**Planning Department
Transportation Development Services**

July 8, 2015

**Re: Advance Auto Parts
San Mateo and Claremont
Traffic Circulation Layout
Engineer's/Architect's Stamp dated NOT STAMPED (H17-D111)**

TCL SUBMITTAL
ADVANCE AUTO PARTS
SAN MATEO BOULEVARD AND CLAREMONT AVENUE
TRAFFIC CIRCULATION LAYOUT

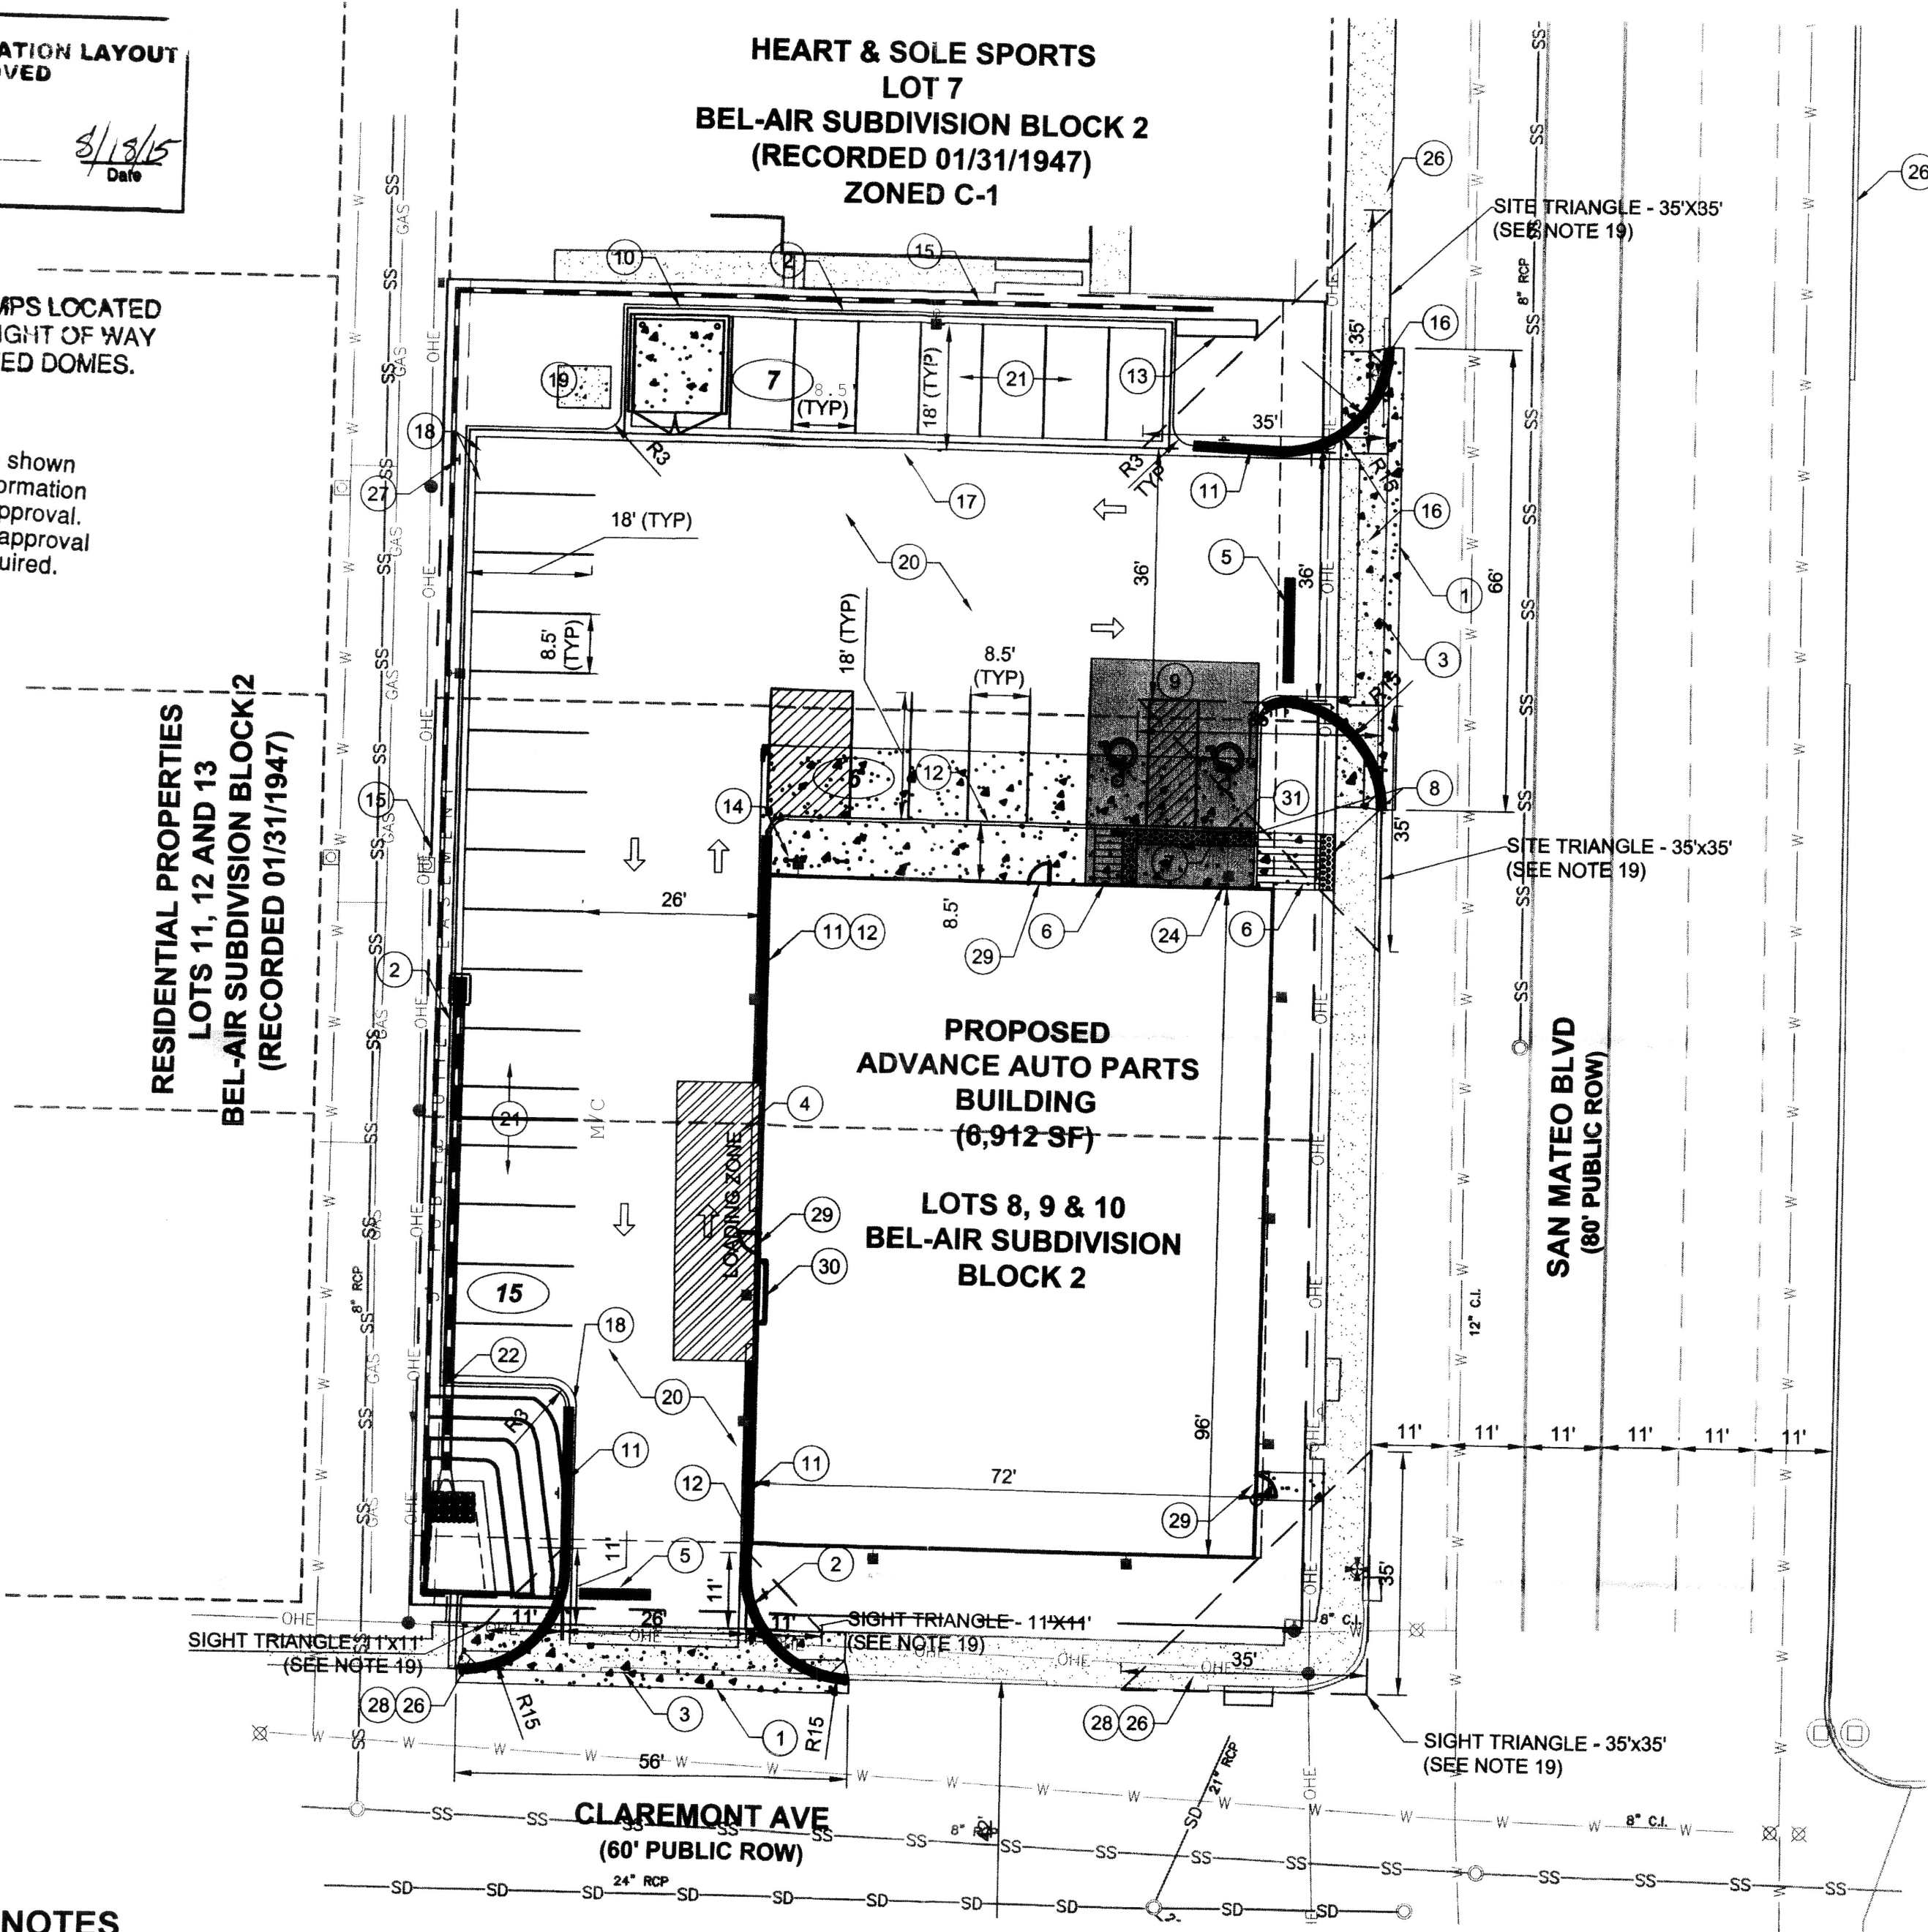
1. The traffic circulation layout must be stamped, signed, and dated by an engineer or architect licensed in the state of New Mexico.
2. Please identify all proposed doors, structures, sidewalks, curbs, drive pads, walls and anything that influences the parking and circulation on the site.

3. Identify the right of way width, medians, curb cuts, and street widths on both sides of the street.
4. Please list the width and length for all parking spaces on the north side of the site.

5. Label the compact parking spaces by placing the words "**COMPACT**" on the pavement of each space, if there are to be any considered for compact car parking.

6. The ADA access aisle shall have the words "**NO PARKING**" in capital letters, each of which shall be at least one foot high and at least two inches wide, placed at the rear of the parking space so as to be close to where an adjacent vehicle's rear tire would be placed. (66-1-4.1.B NMSA 1978)

7. Motorcycle parking spaces must include signage per zoning code.
8. Show drive aisle widths on San Mateo Blvd. and Claremont Ave.
9. List radii for all curves shown; for passenger vehicles, the minimum end island radius is 15 feet. Landscape island radius for delivery trucks, fire trucks, etc. is 25 feet or larger.

10. Service vehicle and/or refuse vehicle maneuvering must be contained on-site; provide a copy of refuse approval.
11. Please provide a sight distance exhibit (see the *Development Process Manual, Chapter 23, Section 3, Part D.5 Intersection Sight Distance*). Please show the 35 ft. detail at the entrance on San Mateo Blvd. and the Mini Clear Sight detail for Claremont Ave.

12. Please specify the City Standard Drawing Number when applicable.
13. Work within the public right of way requires a work order with DRC approved plans.
14. Unused curb cuts must be replaced with sidewalk and curb & gutter. A build note must be provided referring to the appropriate City Standard.
15. Please include two copies of the traffic circulation layout at the next submittal.
16. Final Plat approval from DRB will be required for Building Permit. Please submit Final Plat for TCL approval.
